Online Comment

Application H16-0654-21
Location Jap Lodge, Annexe to Mercia Lodge 65 Pinchbeck Road Spalding PE11 1QF
Proposal Change of use of residential annexe to private dwelling separate from host dwelling including minor alterations to boundary treatments

Name Greg Watkinson
Address Conservation Officer

Site Block Plan as proposed.

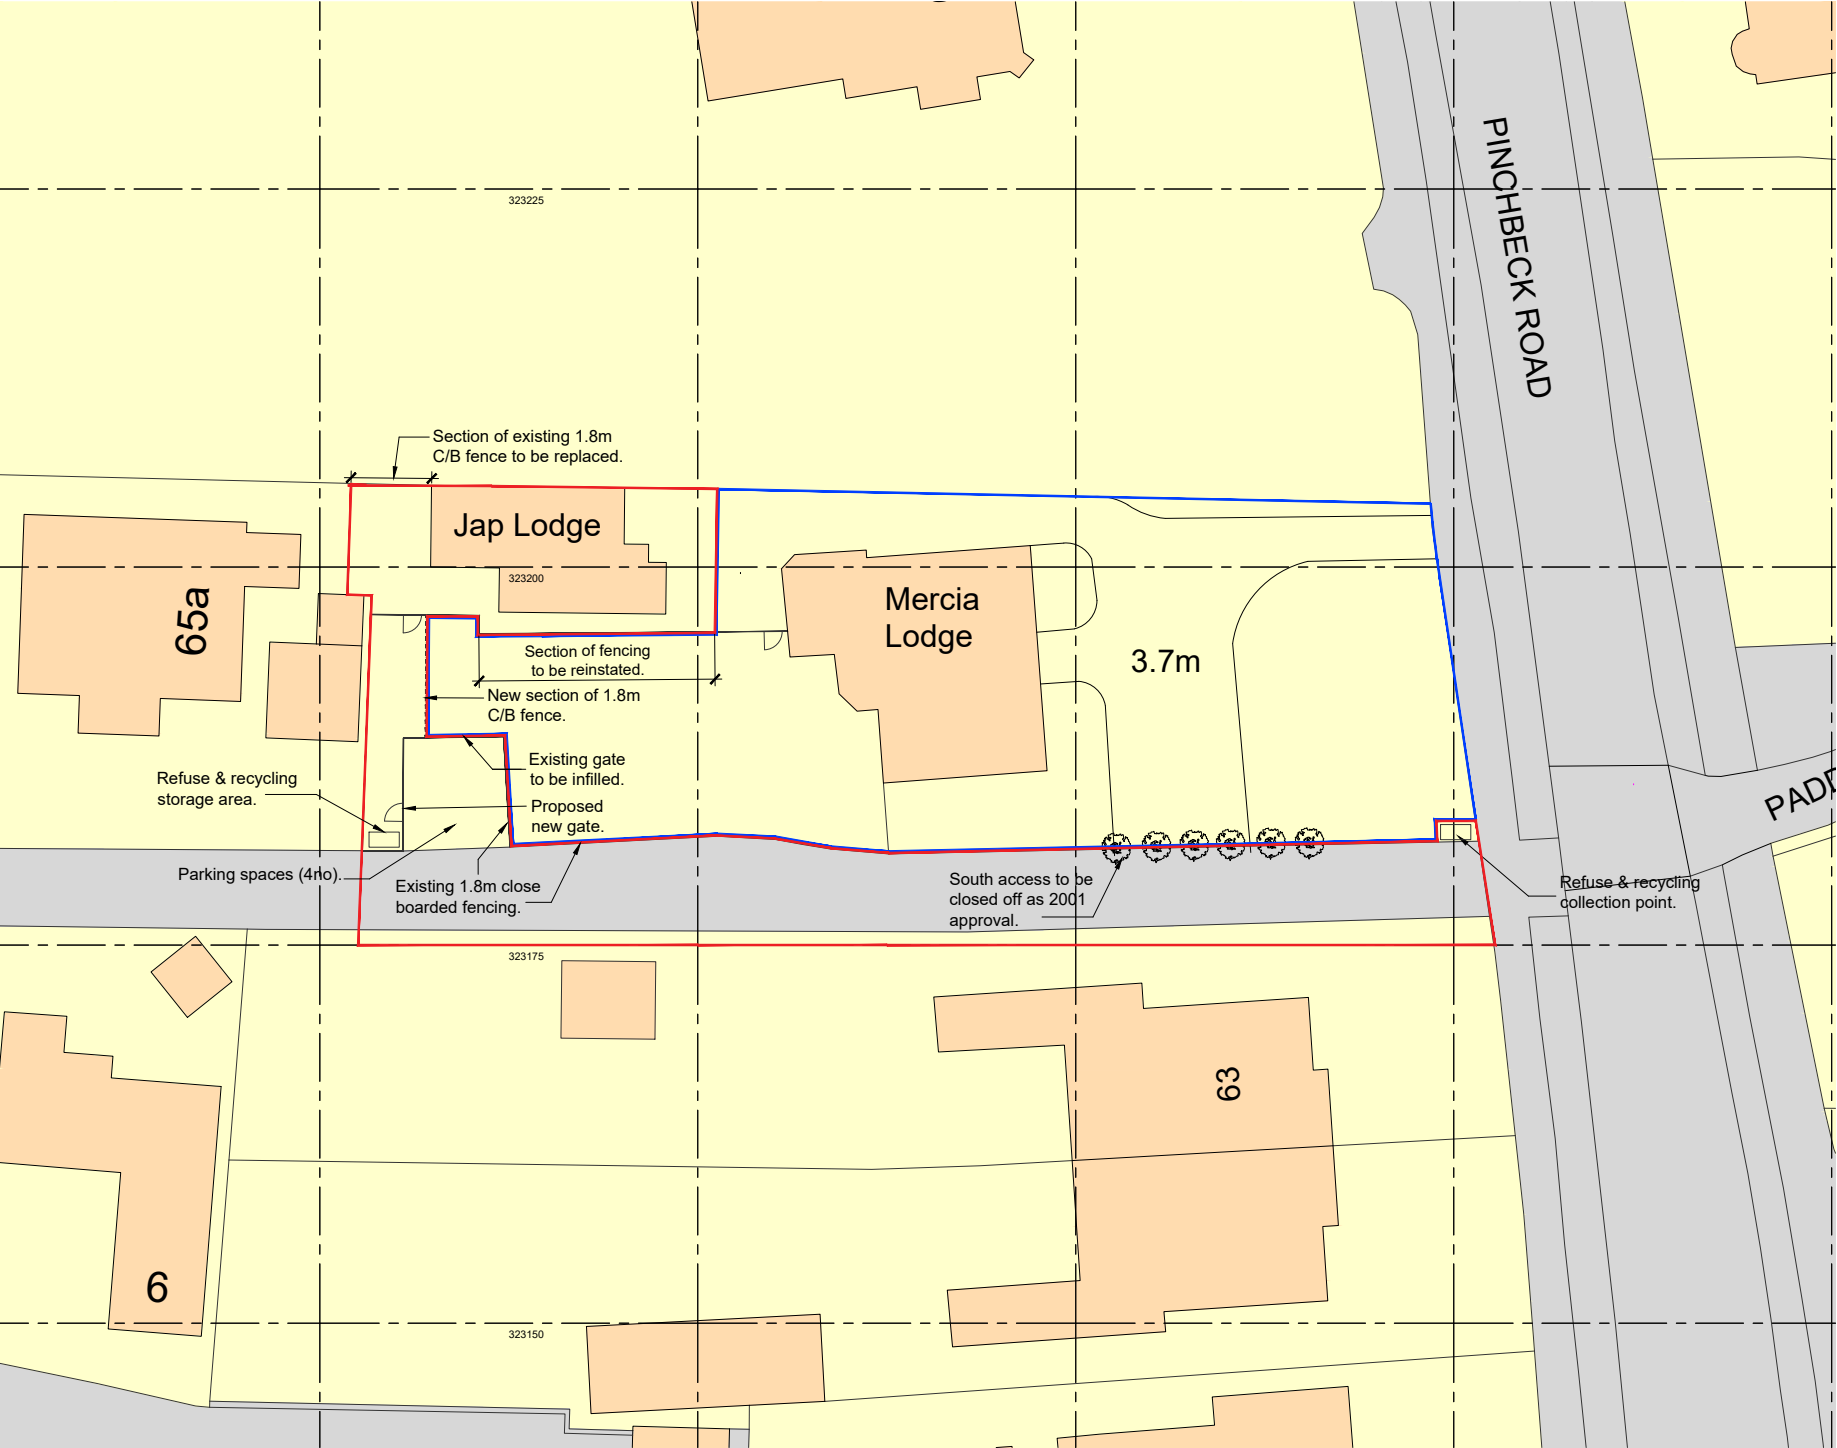
Alterations required to facilitate the change are relatively minor and matching to materials and styles which are already extant on-site. Therefore, i do not consider it to be the case that the proposed physical alterations to boundary treatments would harm the character of the site.
